Comments for Planning Application 21/00006/FUL

Application Number: 21/00006/FUL

Address: 25 Chaloners Road York YO24 2TW

Proposal: Two storey side and single storey front and rear extensions following demolition of outbuilding

Drawing Title
 Existing & Proposed Site Plan & Block
 Plan

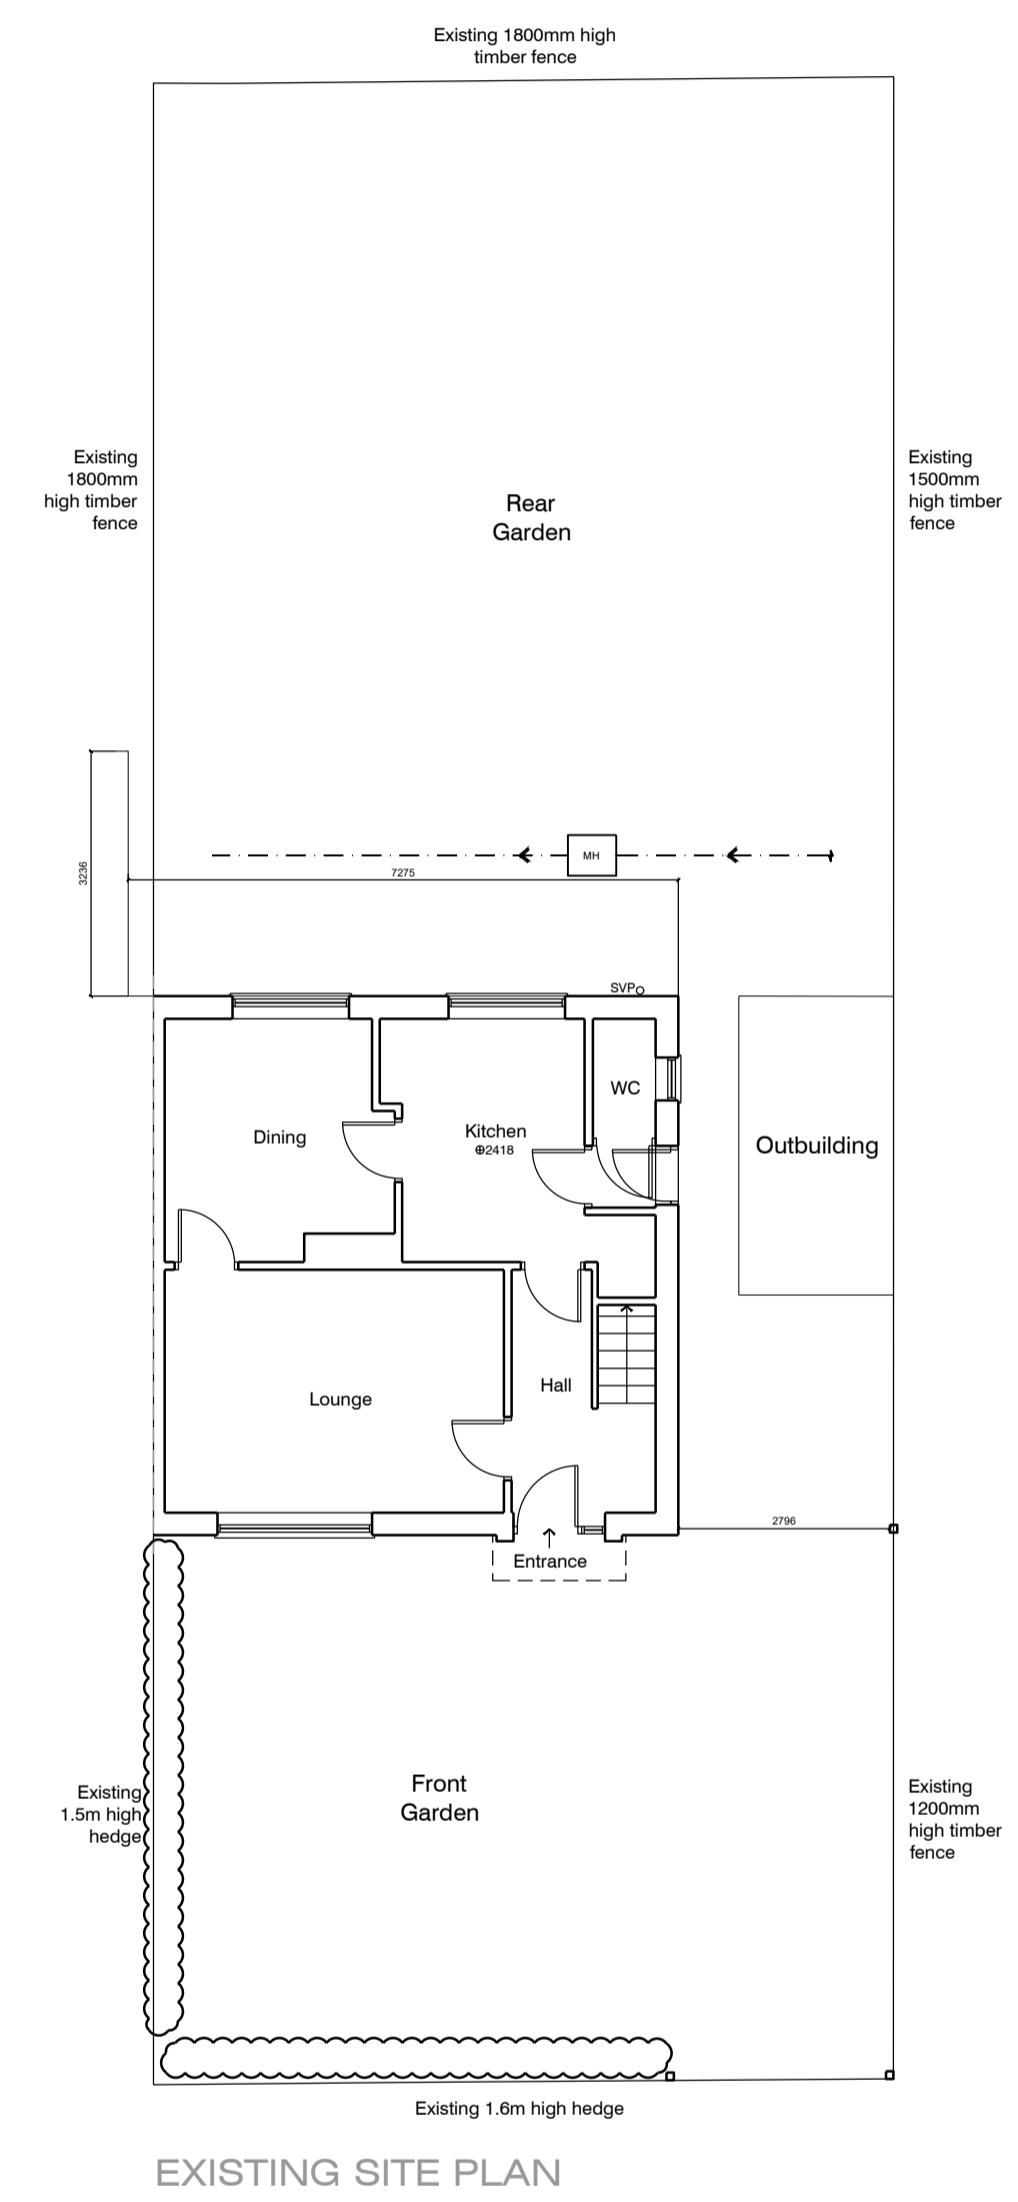
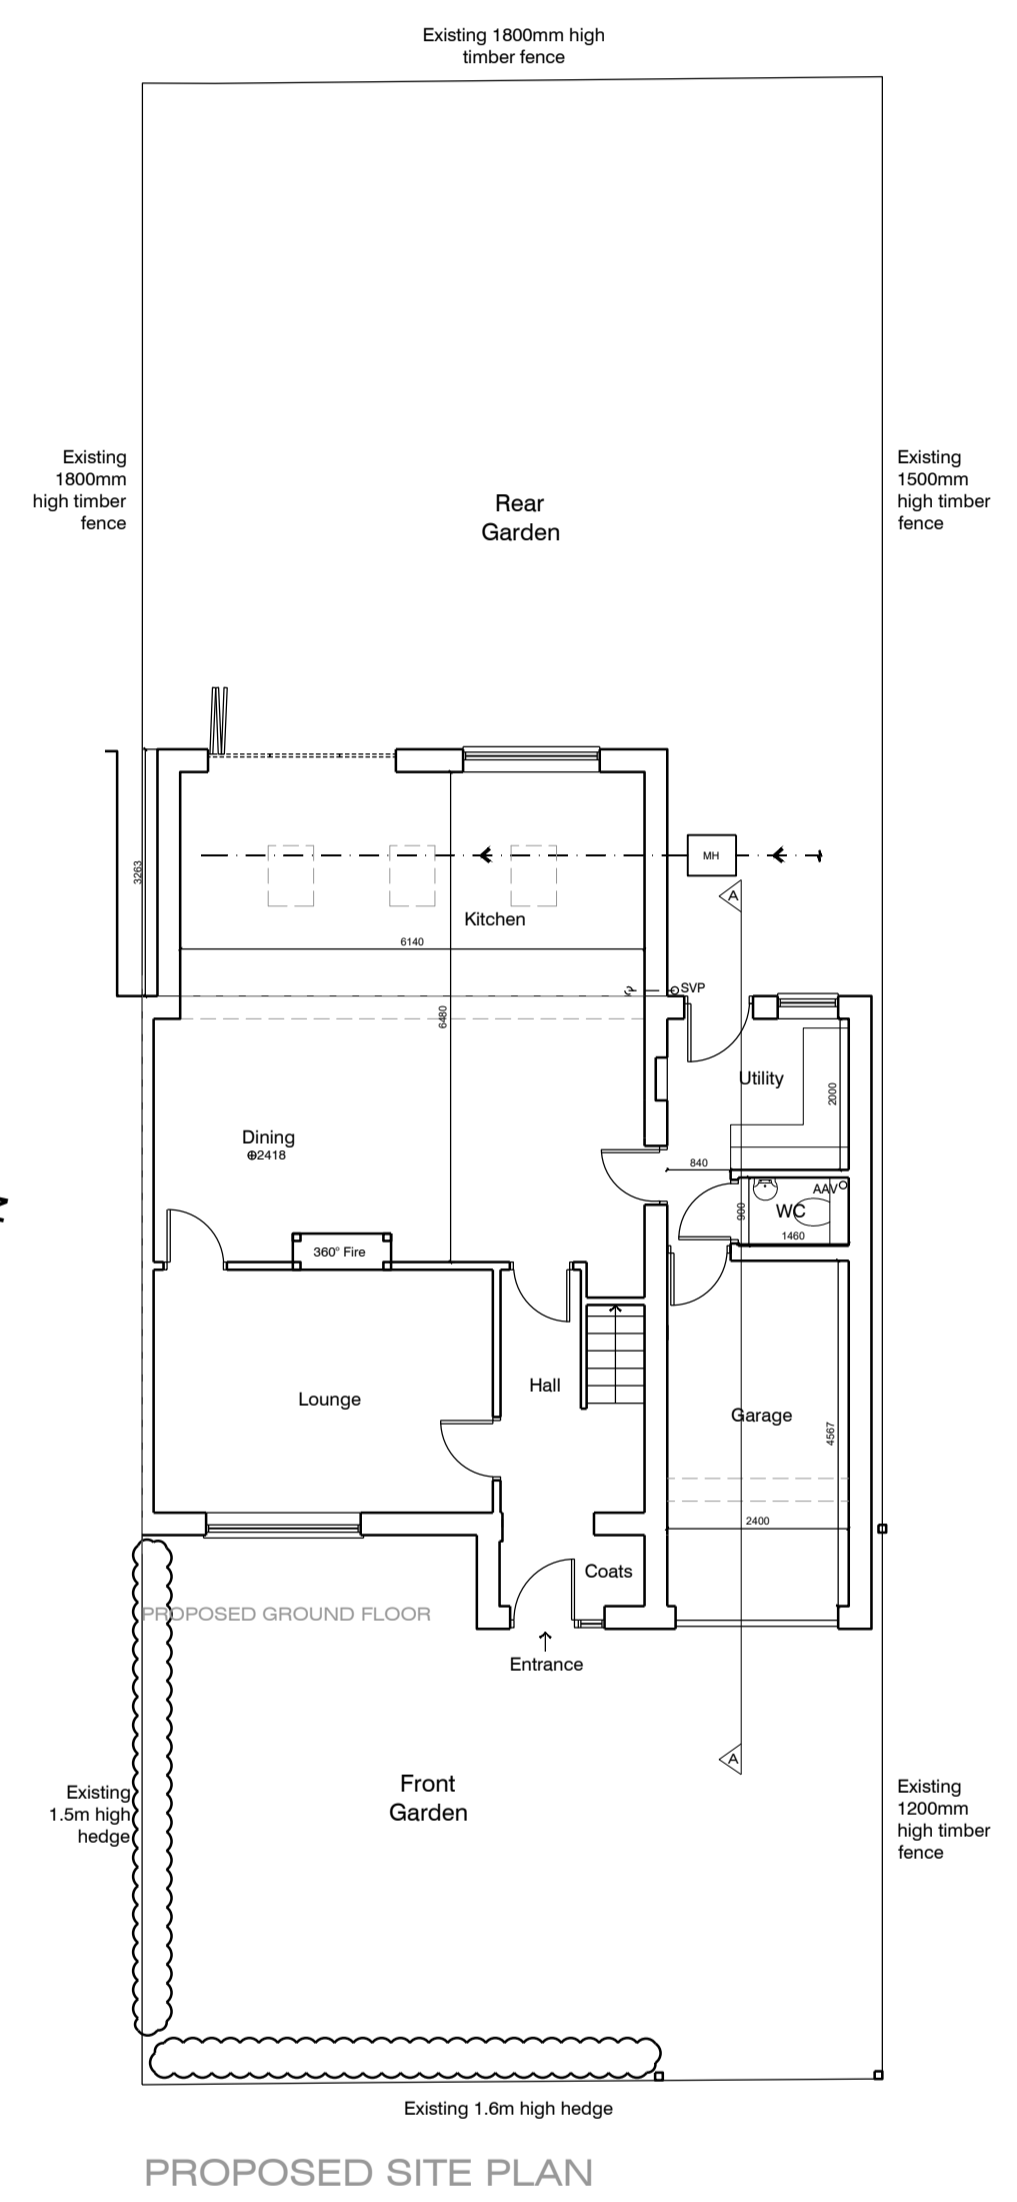
Comment: I note the plan to demolish the outbuilding at 25 Chaloners Road to create space for the planned extension. However the outbuilding is part of a single building, the other half of which is the outbuilding for 27 Chaloners Road.

The dividing wall of the outbuilding is on the boundary line between the two properties and the roof is a single flat asbestos roof which again is shared across both properties.

I note the new extension is built totally on the land area for 25 Chaloners Road, which is fine, but there is no clarity as to how the outbuilding for 27 Chaloners Road is affected by the planned development.
